Re:Extension & Alteration to Top Floor No 3 The Bramblings
Rustington Mr Mike Anstree Ref :R/196/14/HH.
South ELEVATION.

Drawn By:	G . A
Drawing Status	
For Planning	
Project :	Loft Conversion Rear Extension
Mr M Alstee 3 The Bramblings Rustington BN16 2DA	
Drawing	
Elevations and floor plans Location and Block Plans	
Scale :	1:100/1:500/1:1250 @A1
Job No:	A-054
Drawing No :	A-054-01
Revision :	C

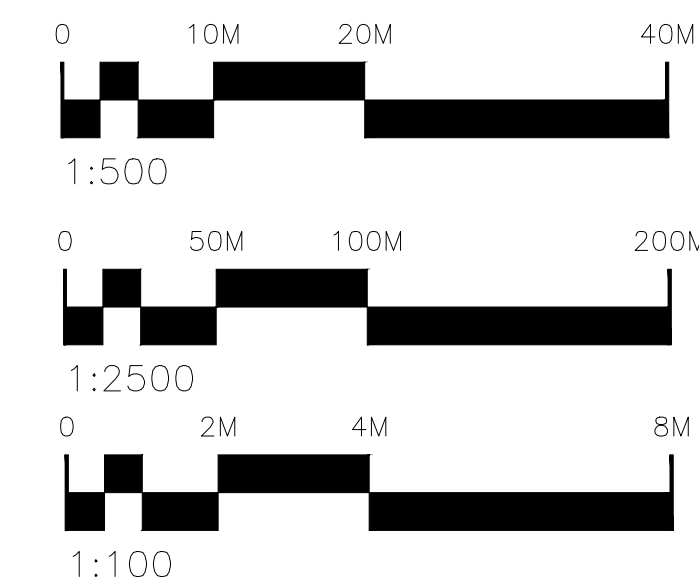
3, The Bramblings and 1 The Bramblings were build very close together in the approx 1930's. 6inches from my 2 bedroom windows is Mr Anstee 12foot hedge and approx 12 feet away is his roof. The proposed plan of two dormer windows in the south elevation would grossly intrude on my privacy and with the extension on the back would cut further the little light that I have. I also believe that he intents to build further out towards my bedrooms which is totally unacceptable to me. My bungalow is on ground level and his extension In the roof would look down on me.

For this reason I would ask you to ask Mr Anstee to only build On the North elevation.
